BUILDING INSPECTION PERMIT

This is to certify that Creating 3rd unit 520 sf

RE: 215-221 Hicks Street – 296-B-14,15,16 – R-5 Zone – application #05-0189

I am in receipt of your permit application to construct a new building for an additional dwelling unit therefore creating a total of three dwelling units on this lot. Your permit is denied because the application is incomplete and because your proposal is not meeting the requirements of the R-5 Zone in which it is located.

TRIPLEX @ 215-221 HICK ST.
PETER DESARNO
& RALPH DESARNO
PLOT PLAN

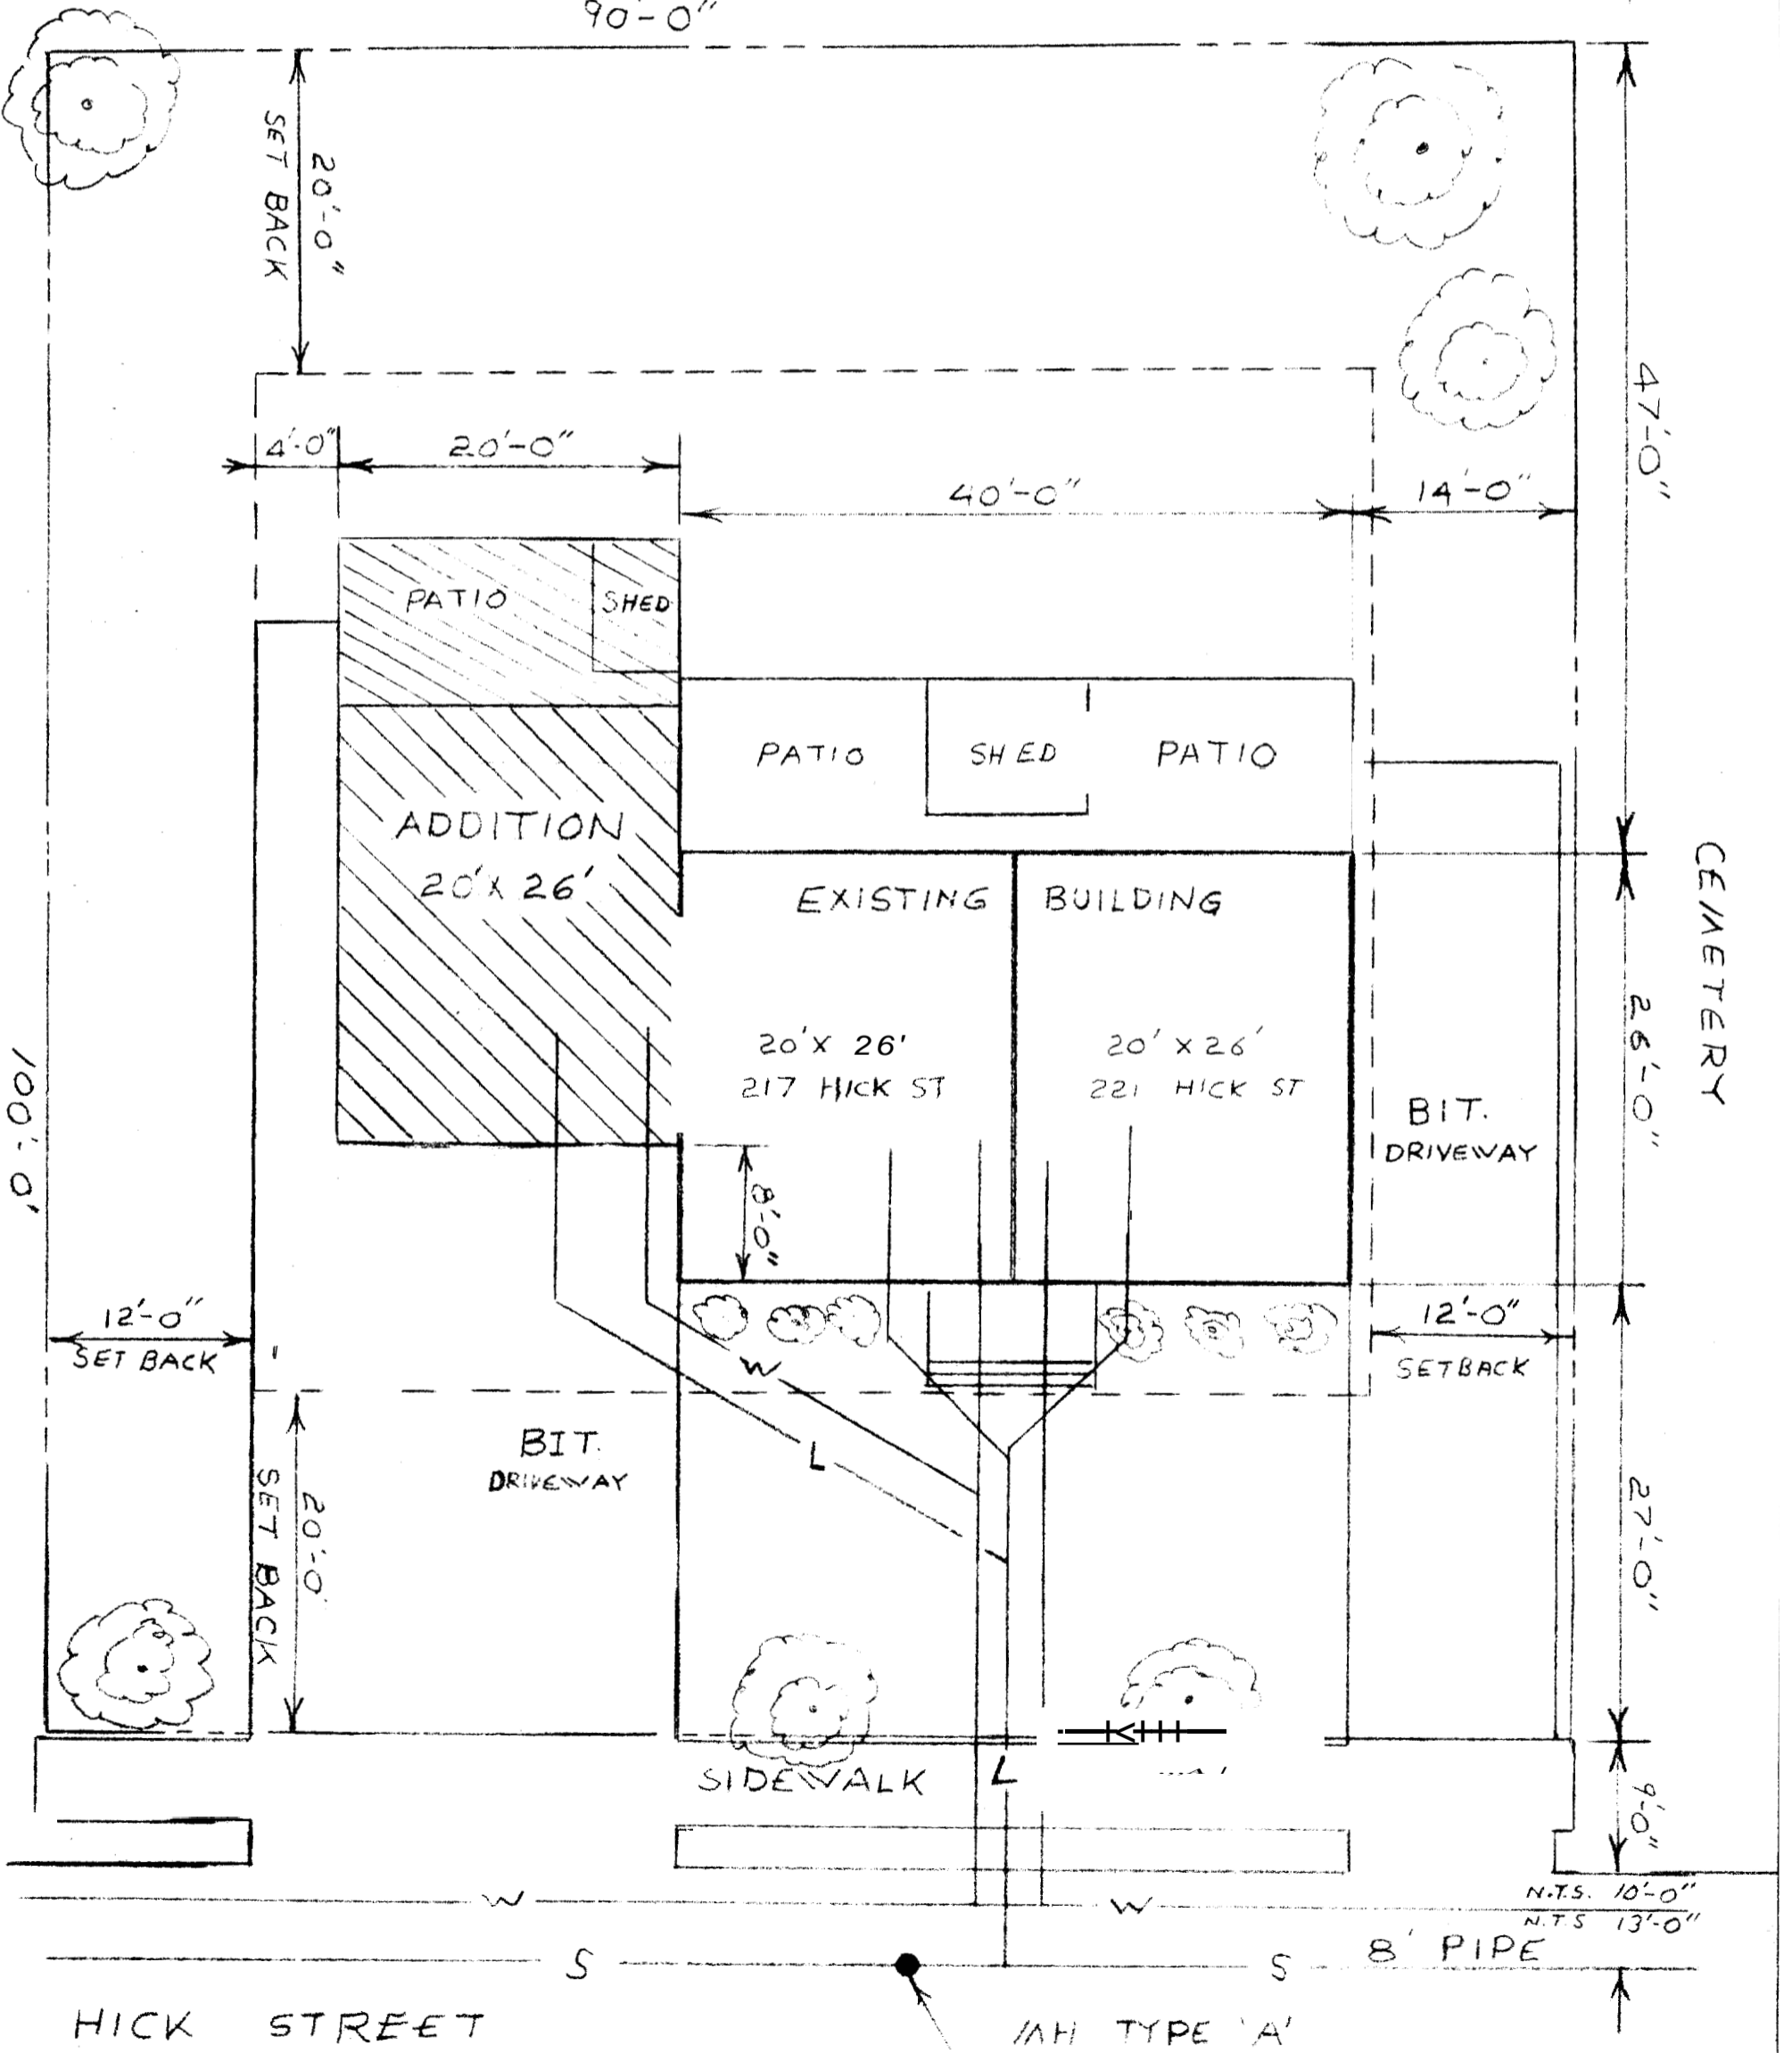
Section 14-117(a)2 of the Zoning Ordinance requires 6,000 square feet of land area per dwelling unit or a total of 18,000 square feet of land area. Your property is only 9,000 square feet of land area. This same section of the ordinance states that this type of proposal is subject to a site plan review. There is no evidence that you have submitted a completed site plan application to the planning division. All zoning issues are a threshold item prior to any other approvals.

Your plan submittal is very deficient. Stamped, scaled site plans are a requirement. I am attaching a copy of our requirements that are attached to our permit applications. ALL requirements shall be met before a full review can be made. I am also sending a copy of a site plan application.
